Appendix A – Summary Response Table

Table 1 Summary of Issues

1 Setback Diagram
SCALE 1 : 200

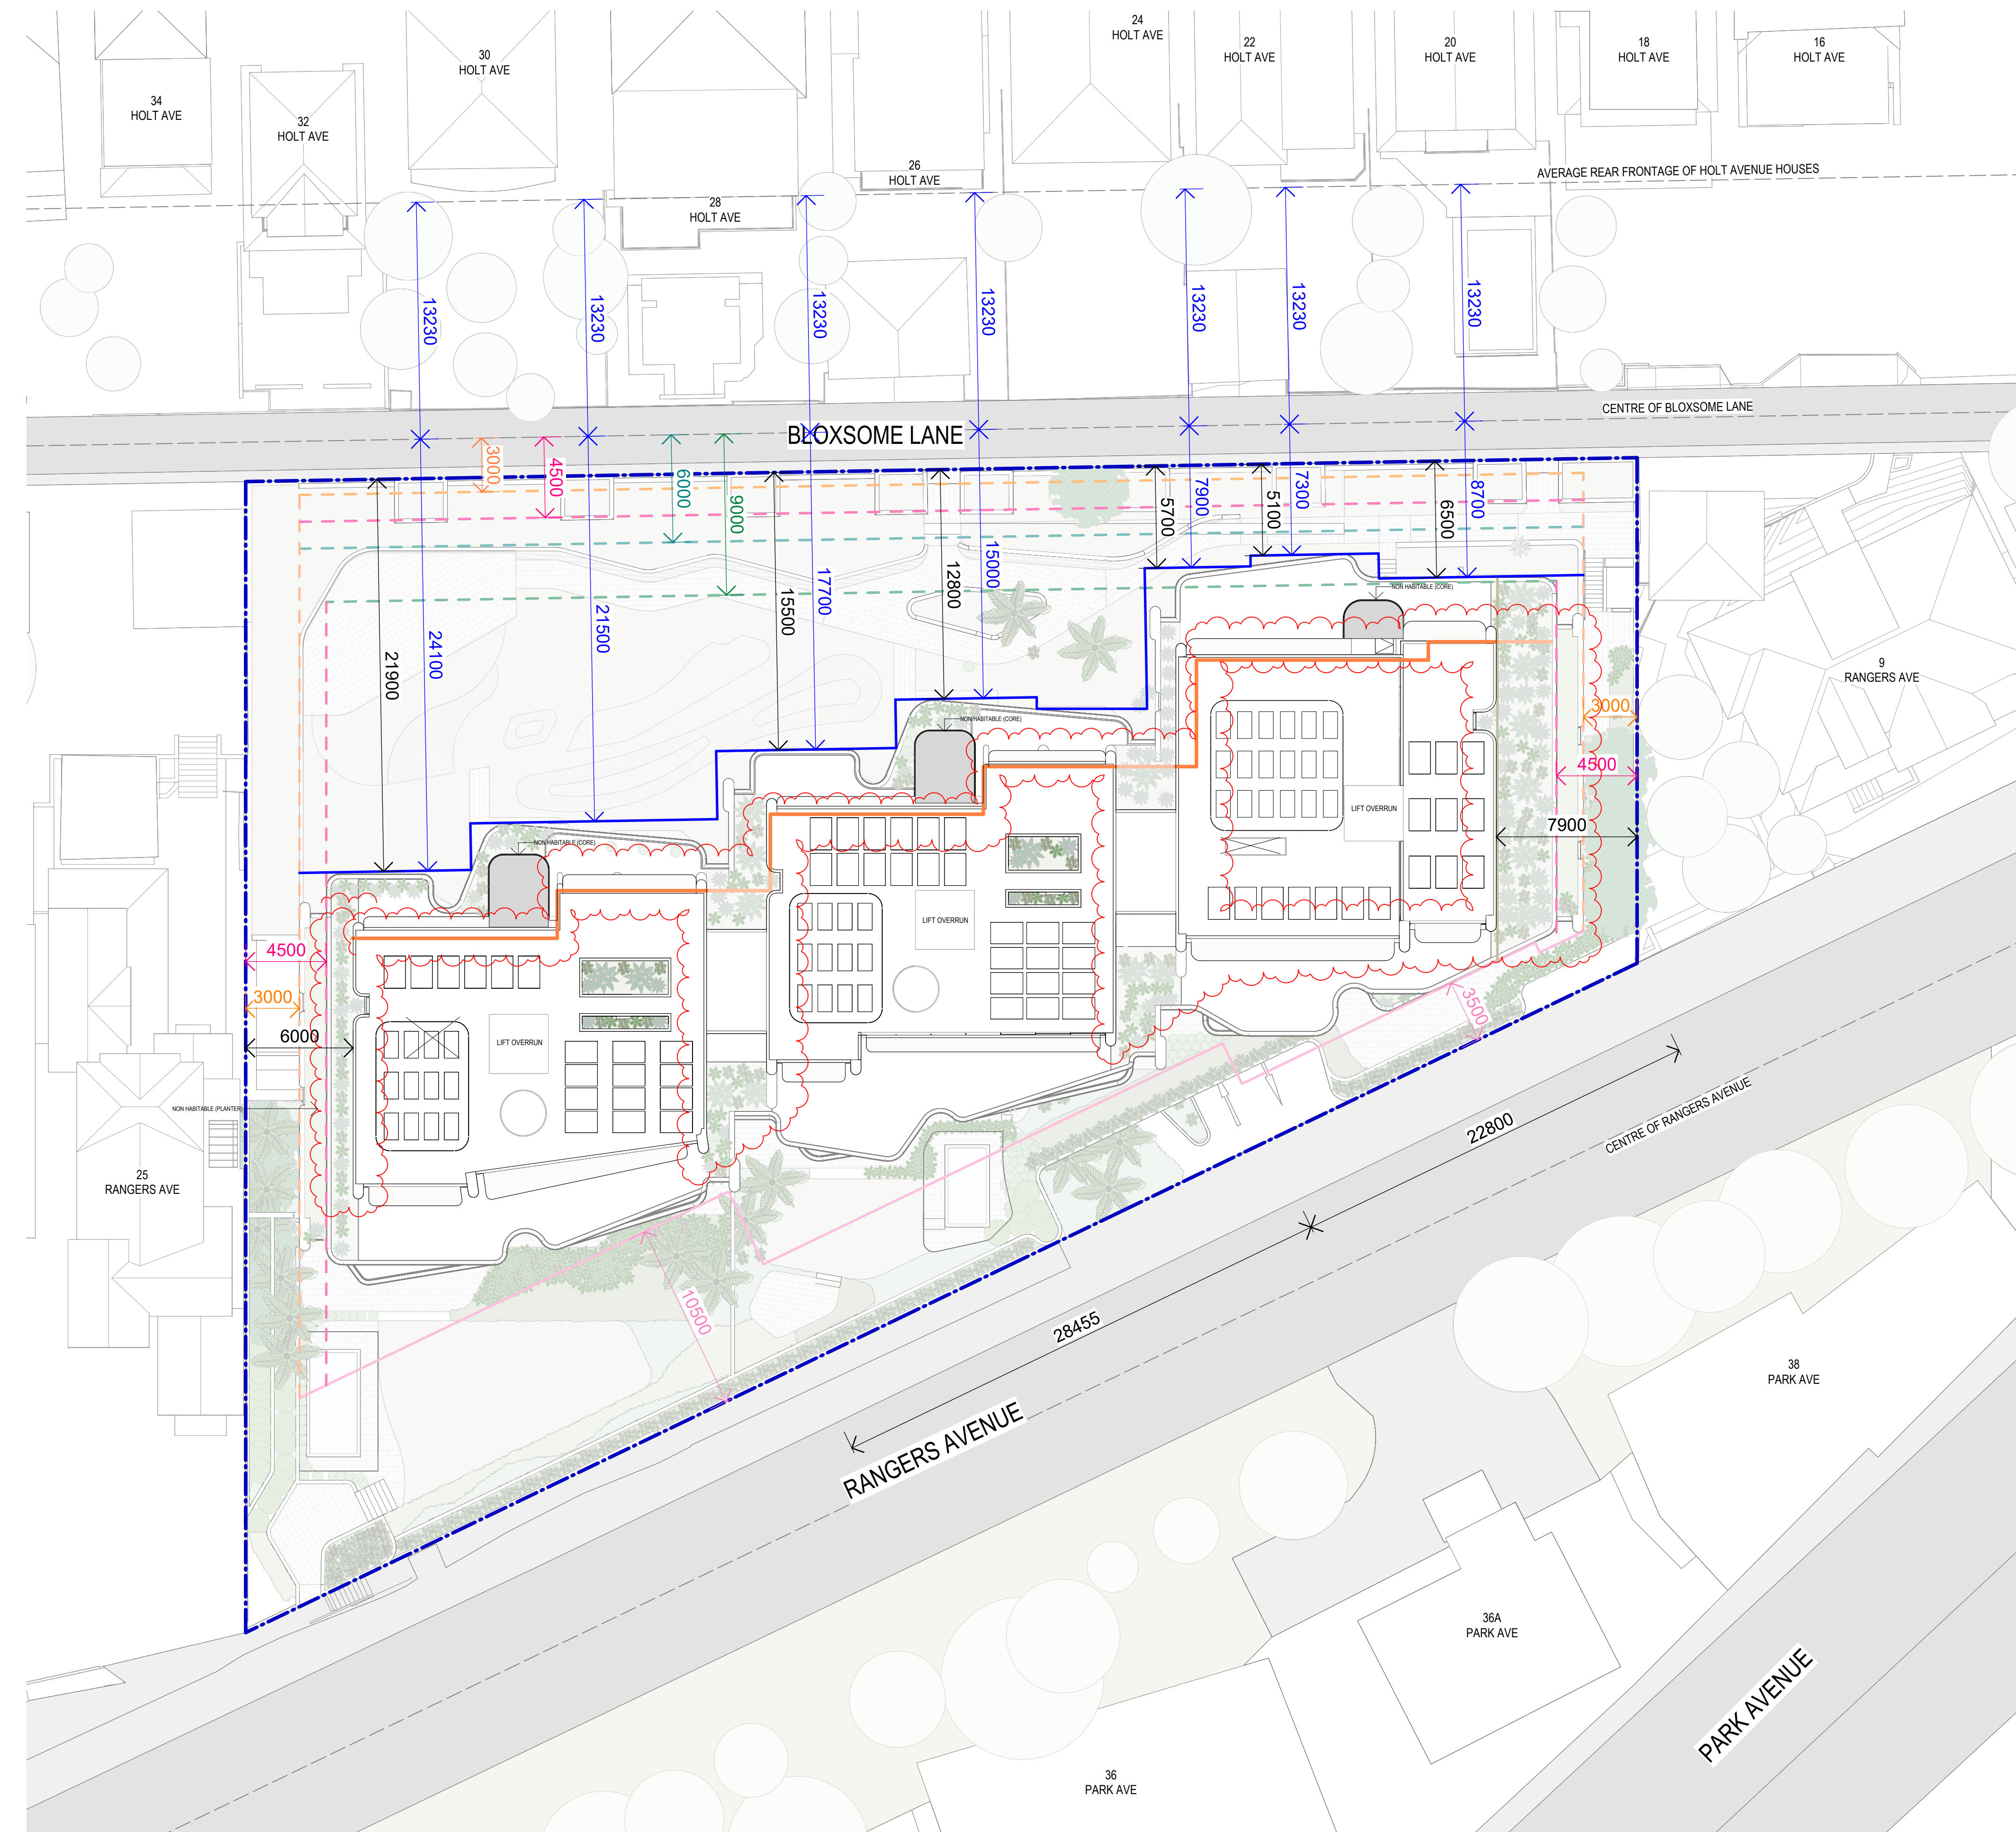
Summary of Issue Raised	Response	Supporting Document
NSW Department of Planning, Housing and Infrastructure 10 items		
<u>Building Separation:</u> 1. The Apartment Design Guide (ADG) provides design criteria for building separation to ensure residential development contributes to the amenity and character of an area provides appropriate massing and spaces between buildings. It also assists in providing residential amenity including visual and acoustic privacy, natural ventilation, sunlight access and outlook, and area for open space, landscaping and deep soil. The building maintains side setbacks of 3 m up to Level 5 (west) and to Level5/6 (east), which are less than the Apartment Design Guide (ADG) design criteria (6 m up to four storeys and 9 m for 5 to 8 storeys for habitable rooms and 6 m for non-habitable rooms). The Department acknowledges that the proposal has sought to provide blank walls where possible. Notwithstanding, given the six-storey scale of the development, the limited side setbacks do not allow sufficient space between the neighbouring	The plans have been revised to increase the setbacks on the eastern and western sides of the site. On Levels 4 and 5, the setbacks have been increased from 3 metres to 4.5 metres, while Level 6 now provides setbacks of 7.8 metres and 6 metres. These amendments to the plan ensure compliance with the ADG separation from neighbouring buildings on both sides of the site. Additionally, the provision of blank walls in the eastern and western sides of the property with obscure / frosted windows on both sides help reduce the impacts on privacy towards the eastern and western sides of the site. This directly responds to concerns around privacy and overlooking and is a preferred outcome compared to 6m setbacks with habitable facades and balconies overlooking the side boundaries. Supplementary planting has also been provided along the setback zone at Level 4 and the upper level, providing a landscaped buffer to create visual separation to other neighbouring structures. The footprint of the basement carpark design has also been reduced to increase the northern setback, along Bloxsome Lane. The basement is now setback 3m, with two corner areas setback 6m allowing for deep soil planting along the full extent of Bloxsome Lane.	RTS Appendix C, D and E

buildings to mitigate the change in scale and also reduce opportunities for landscaping and deep soil as well as increase view loss impacts (see point 5 below). It also compromises the building setbacks for future developments on both sides, which can only propose blank walls to maintain appropriate building separation in the future. The Department therefore requests that you increase the side setbacks and building separation to neighbouring properties to the east and west, to contribute to the desired future character of the area, provide opportunities for additional landscaping and reduce the reliance on blank walls and highlight windows to mitigate impacts. <u>Basement Setbacks:</u> 2. The proposed basement has zero setbacks to the rear and side boundaries, resulting in compromised deep soil zones and limited planting within the setbacks. The Department requests that you explore options to increase basement setbacks (especially to the rear) by rationalising the basement footprint, which can be achieved by reducing the amount of car parking (see point 7 below), amending the internal layouts or other design changes, to increase the setbacks to allow more deep soil planting to contribute to the landscaped character of the area.

1 ELEVATION - NORTH (BLOXSOME LANE)
SCALE 1 : 125

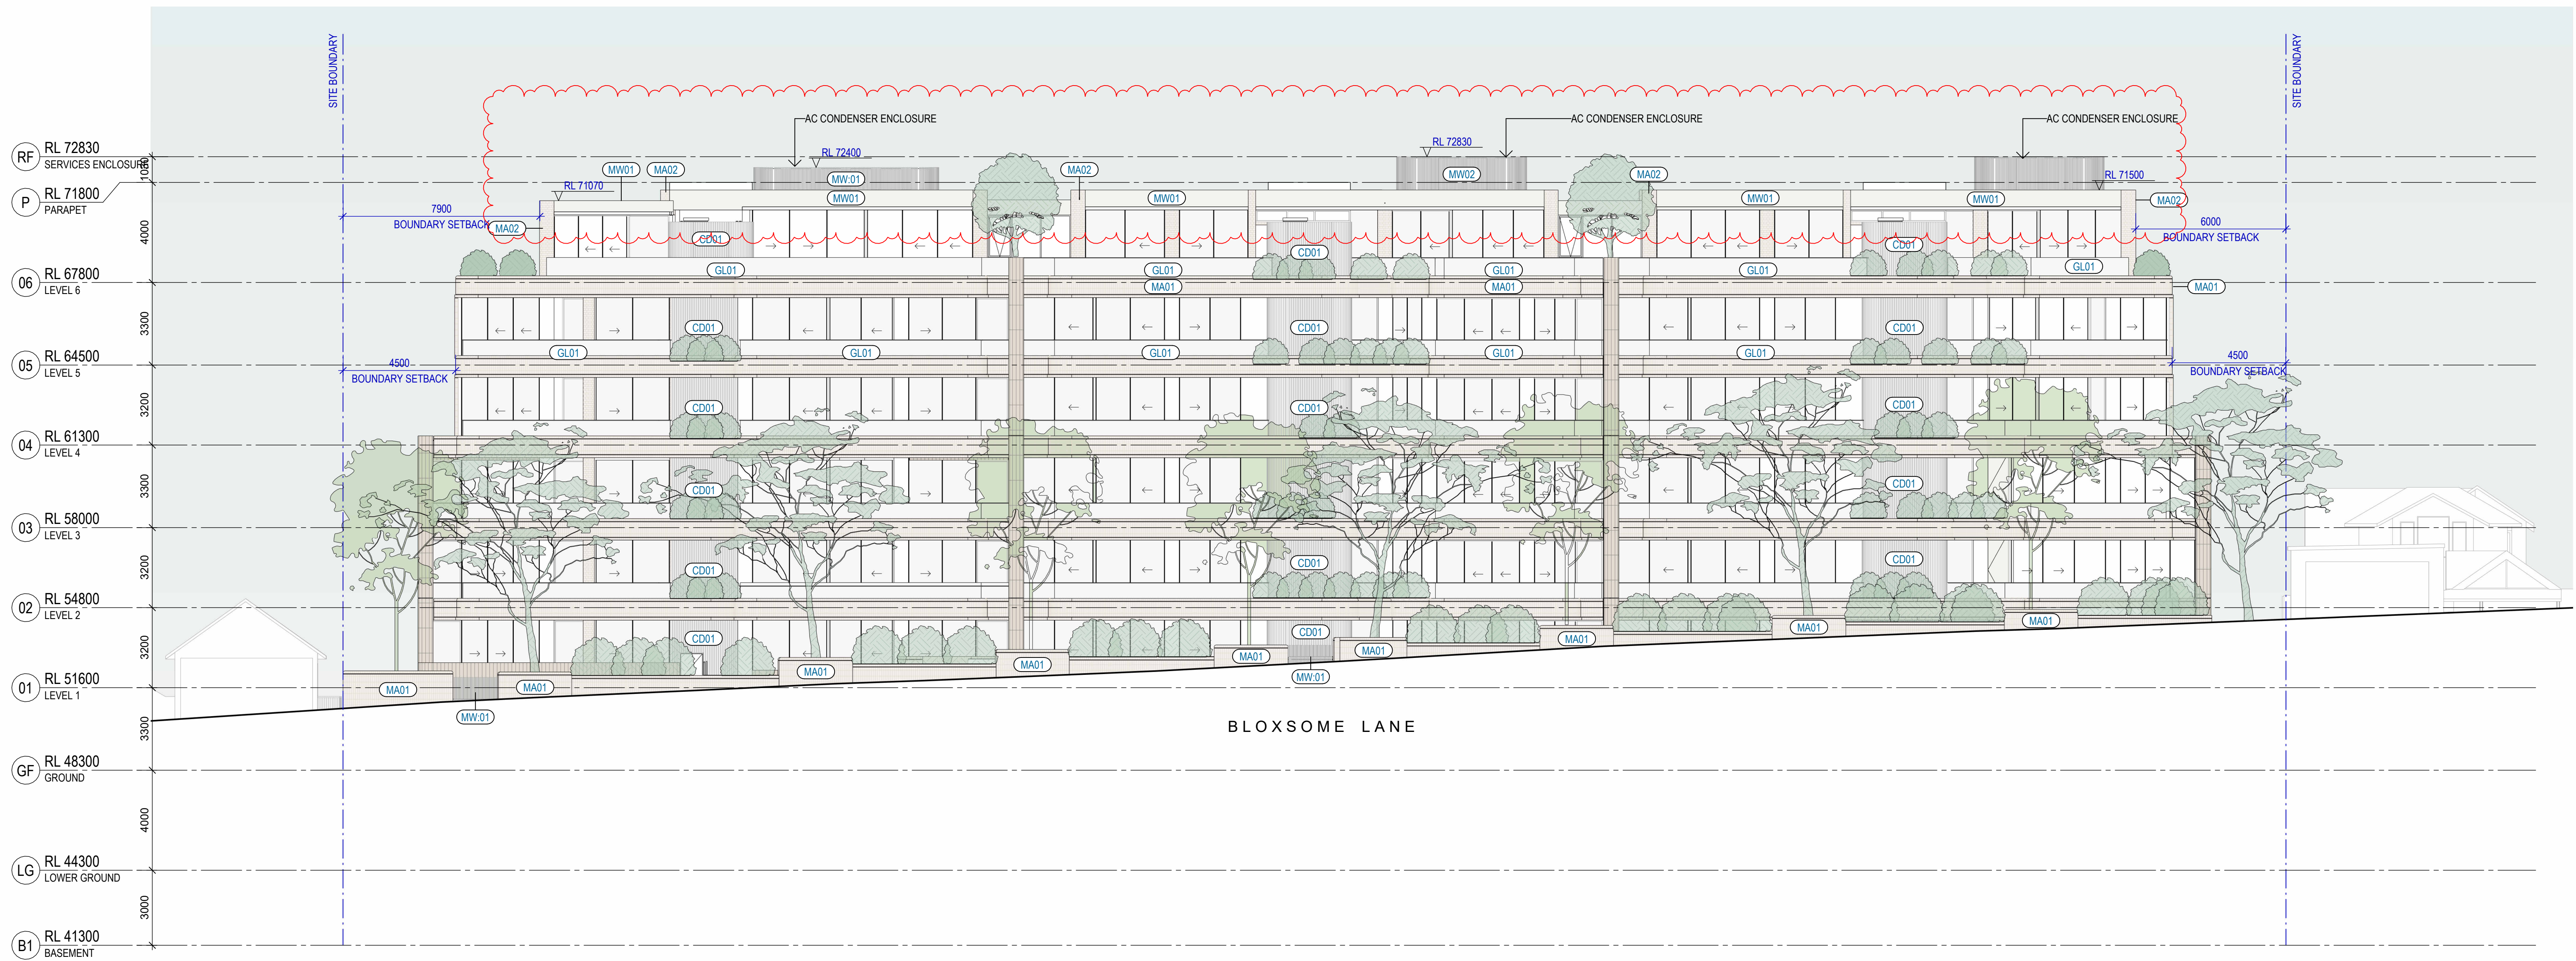
<u>Built Form & Character:</u>	The northern façade is highly articulated into three separate modules. The base build has recesses of 4m and 8m between the blocks, as shown below.	RTS Appendix C, D, E and F

3. The proposed building lacks facade articulation and presents as a singular and dominant mass that will be incongruous with the character of the surrounding residential context, in particular to the north, where the site adjoins Holt Estate Heritage Conservation Area (not within the Low and Mid-rise (LMR) housing area). The Department is concerned that no transition in scale is provided to the surrounding lower scaled developments and heritage significant areas to the north. The lower ground level, while not being counted, presents as an additional storey to the public domain and contributes to perceived height and scale. Cumulatively, the proposal does not address the desired local character of the area as required by Chapter 4 of the State Environmental Planning policy (Housing) 2021 (Housing SEPP).

Consequently, you should consider options to further articulate the building facades fronting Rangers Avenue and Bloxsome Lane to reduce the perceived bulk and scale of the buildings. This may include opportunities for:

- reducing continuous façade lengths, separating envelopes where possible
- incorporating recesses that can be visually perceived from the public domain
- adding further façade articulation, a variety of materiality and architectural expression to break down the strong horizontality

In addition to the stepping of the base building, the balconies have been designed and curated to be of different shapes and sizes to provide for visual interest and as a measure to avoid direct overlooking. The design incorporates landscaping between the balconies, which wraps around the encased service stair. At the upper level, the glazing line of the façade is further recessed, providing for reduced building form.

Comparative to a standard block form, the proposal provides for a superior urban design response, with deep recesses, variations in setbacks and variation in balcony orientation, form, shapes and sizes. The combination of measures used in addition to the materiality palette provides a skilful urban design response to the north.
